Recommendation Report for Planning Permission for Works or Extension to a Dwelling

REF NO: BE/37/21/HH

LOCATION: 19 South Way
Bersted
PO21 5HB

PROPOSAL: Removal of 3 No existing lean-to structures, erection of single storey side & rear extension, loft conversion to form new 2nd floor with roof alterations to form gable end with rear dormer projection & detached outbuilding to be used as annexe to existing dwelling.

2nd floor plan

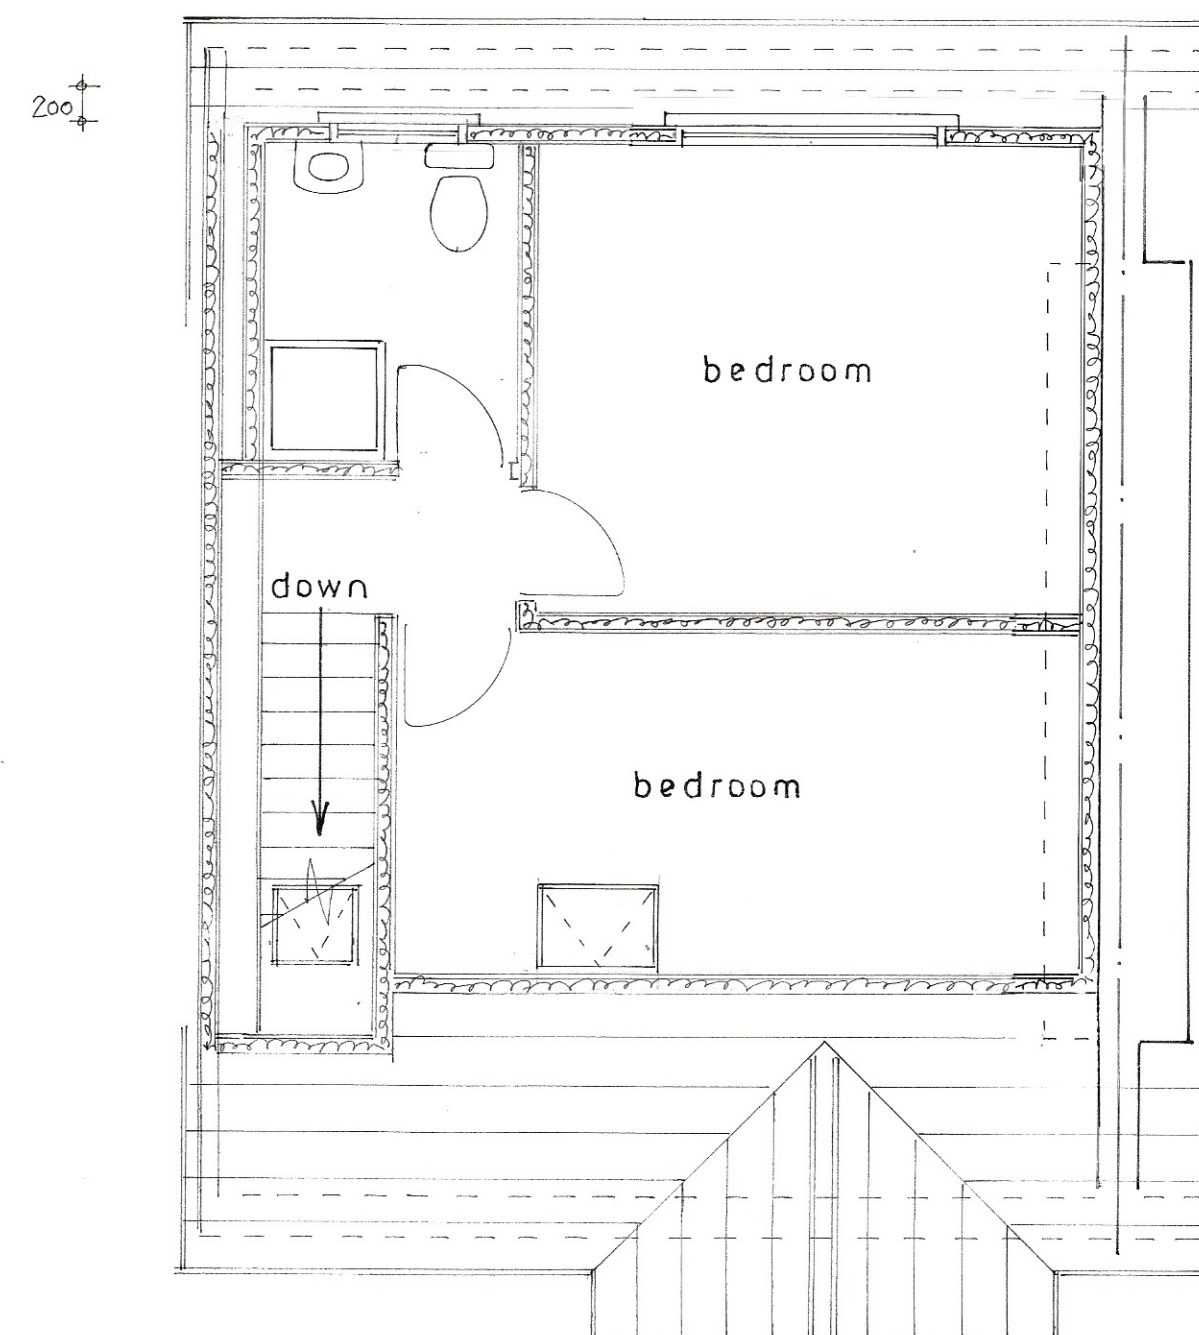
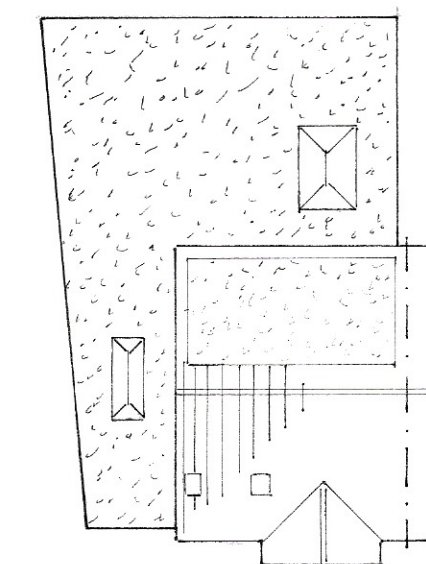
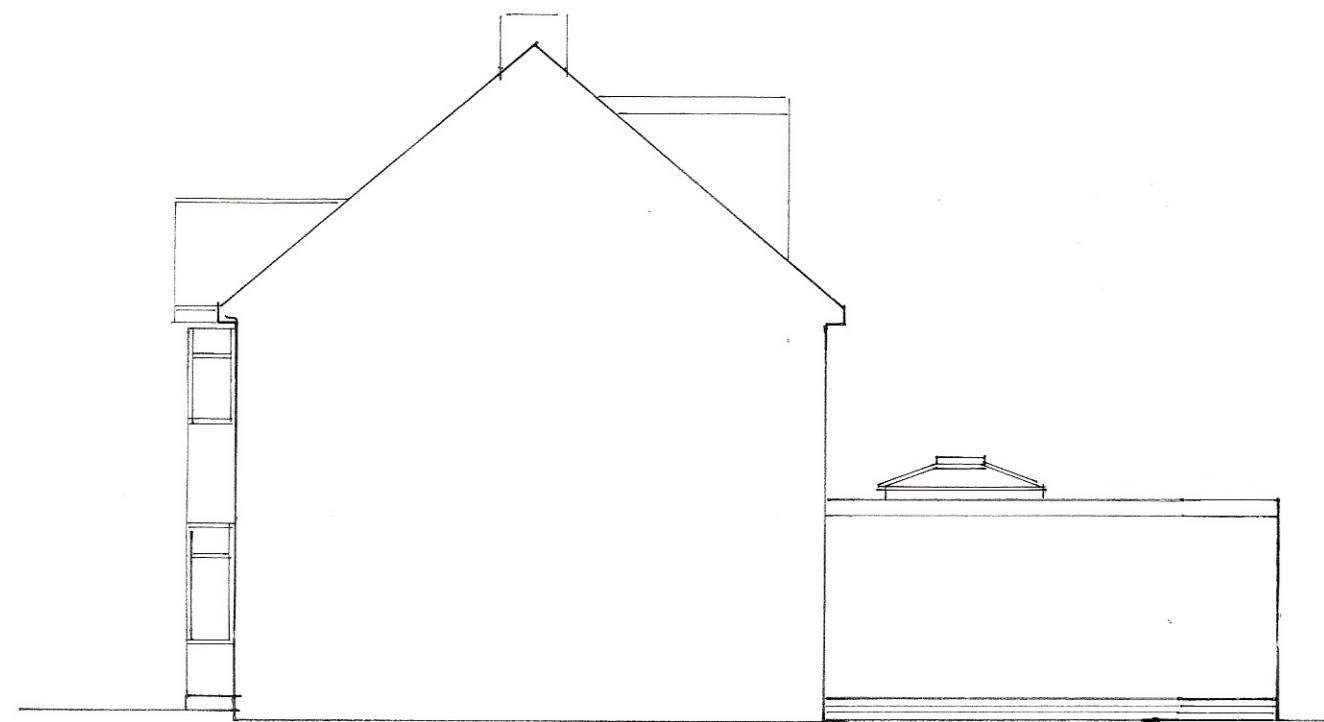
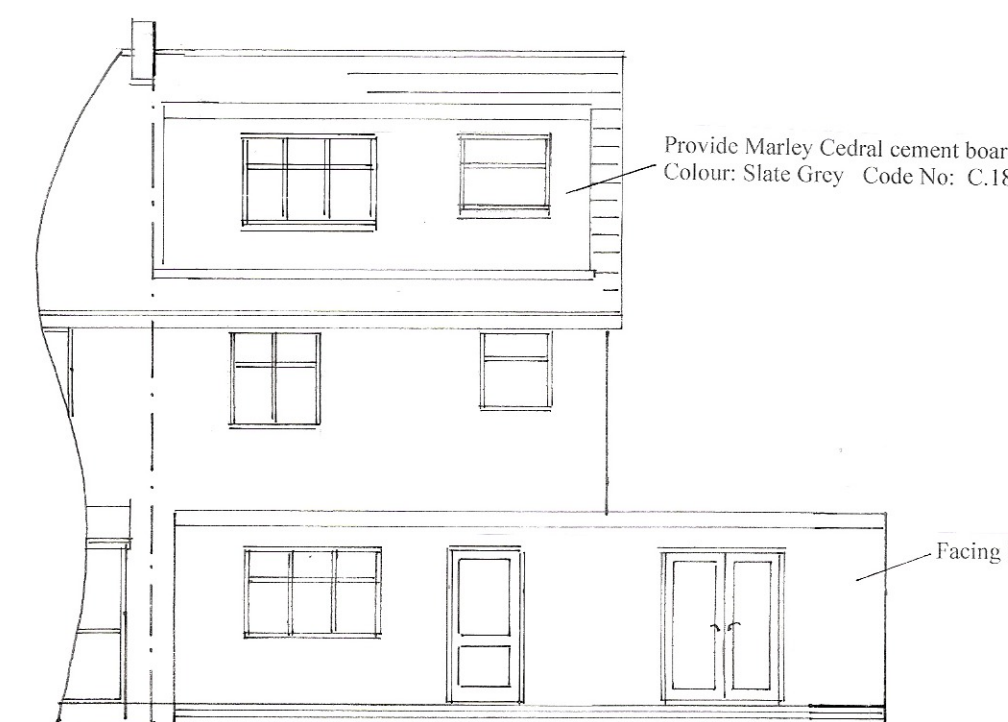
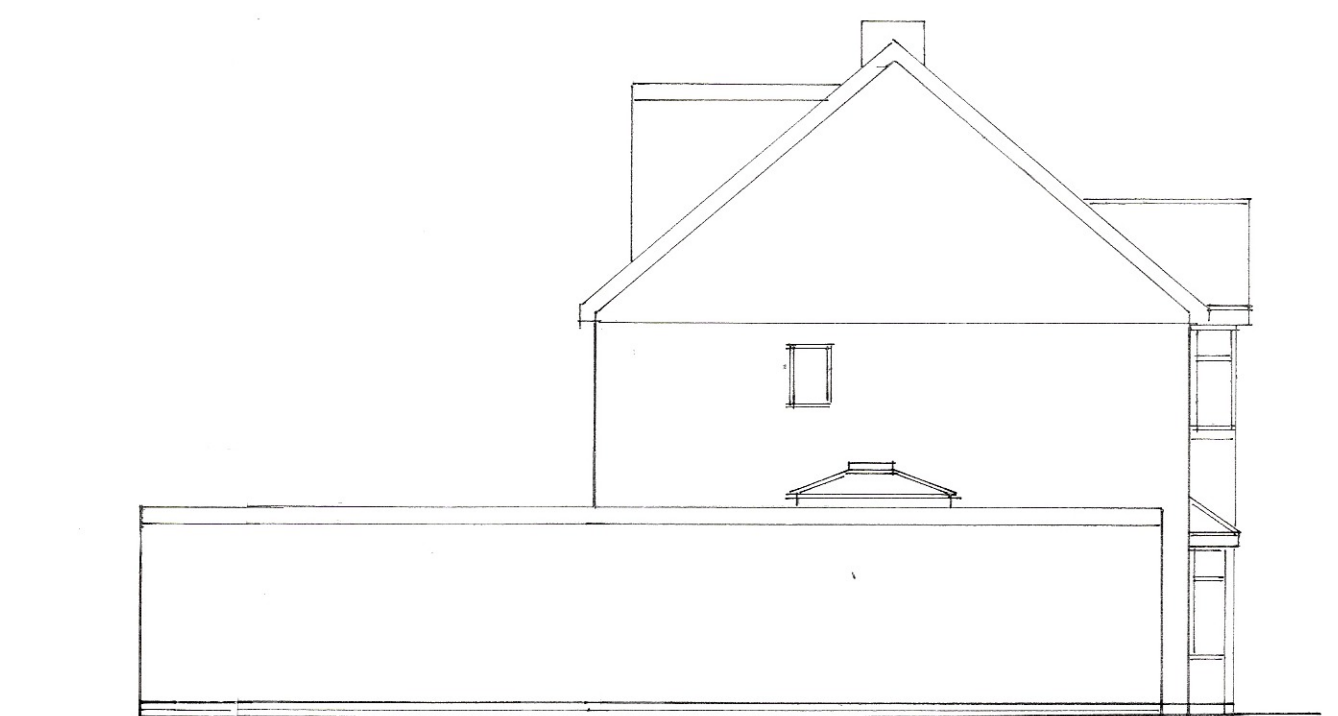
The roof shape of the dwelling will be changed with hipped to gable ends and rear dormer. Whilst these changes result in a change in appearance of the host dwelling, they are not considered to result in a harmful impact upon the character of the area. This is as a result of the varied character of the dwellings in this area allowing there to be no uniform character. The development of the roofspace is not considered to result in a harmful impact upon the character of the host dwelling, as a result of the scale and design of the alterations. Elements of the roofspace extension may fall under permitted development.

With regard to loss of privacy through overlooking, all of the proposed openings for the extension and outbuilding are at ground floor level, and therefore, do not provide any views different to those available from the application site at current. However the dormer and gable end will create additional views into the neighbouring properties.

PROPOSED DETACHED OUTBUILDING AT 19, SOUTH WAY, BOGNOR REGIS
FOR MR.O.SAPOZHNYK.

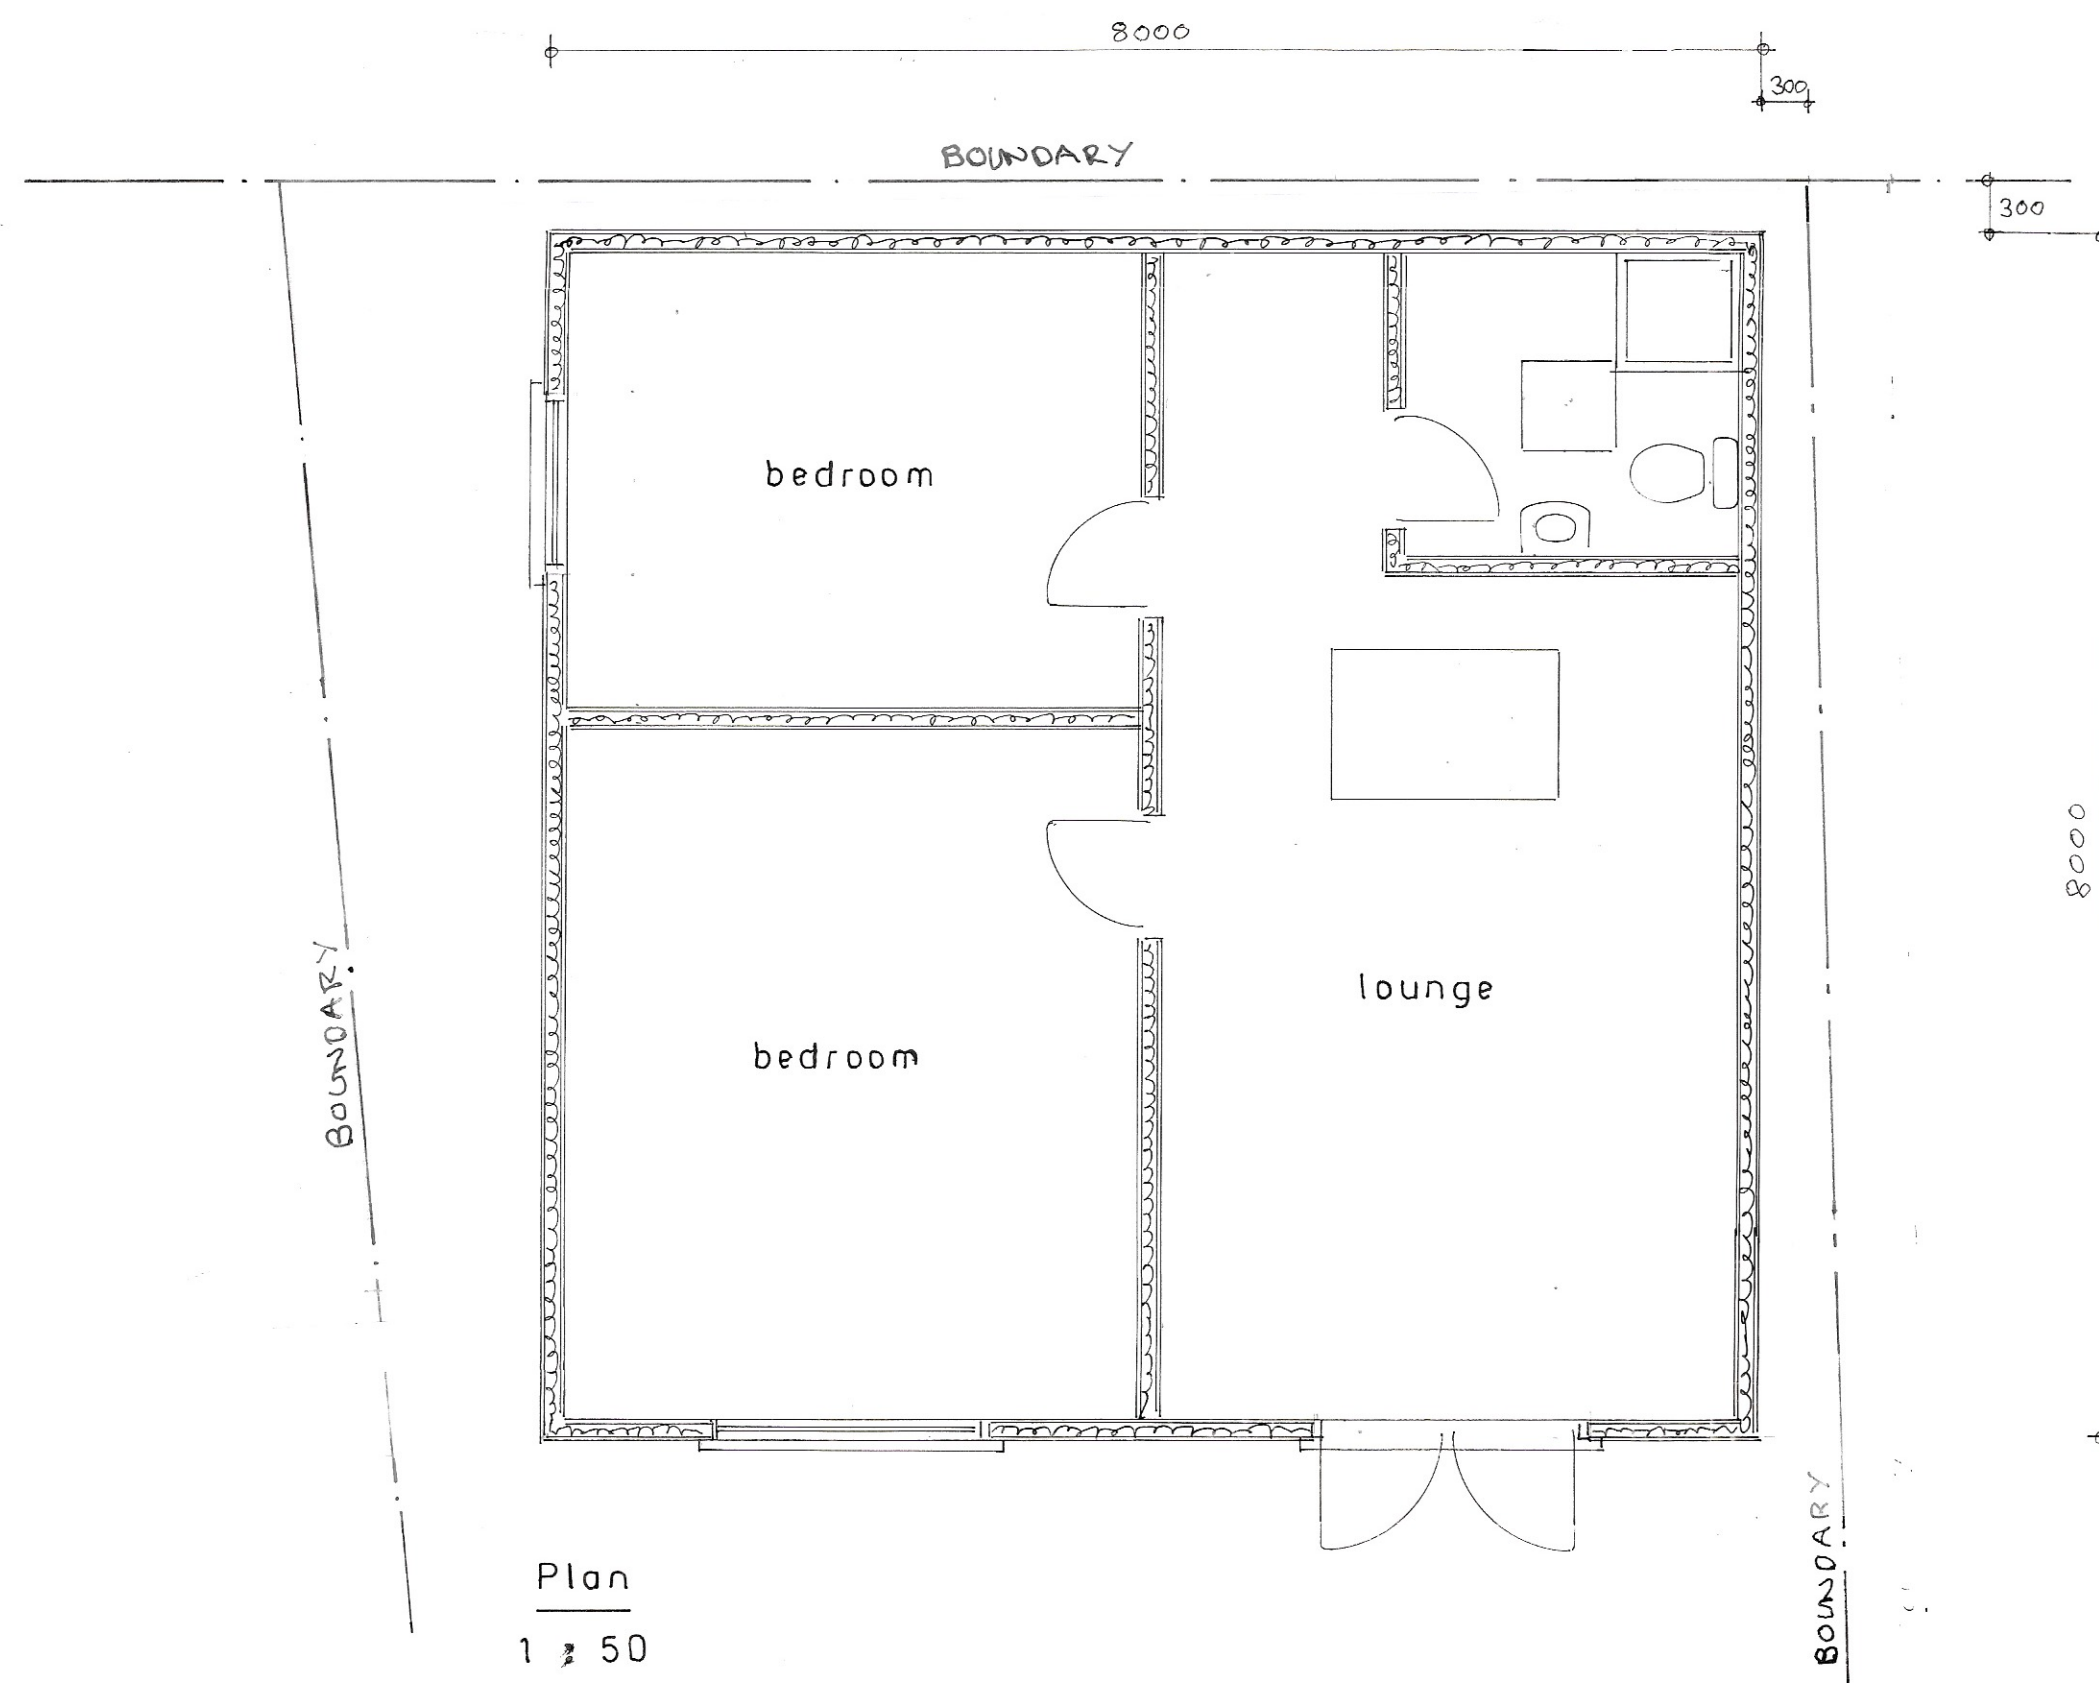
The annex to the rear is single storey and as such is not considered to have a detrimental impact on the design and visual amenity of the proposal.

The scheme then has a further, large, outbuilding in the rear garden which will be used as an annex. This adds to the overdevelopment of the site measuring 7.9m in depth and 8m in width this is a considerable outbuilding. With only 0.6m to the boundary and a height of 2.95m this is unneighbourly and adds to the overbearing impact on the neighbouring properties with substantial bulk the majority of the way along the boundaries. The building is large and would contribute to the overdevelopment of the site.
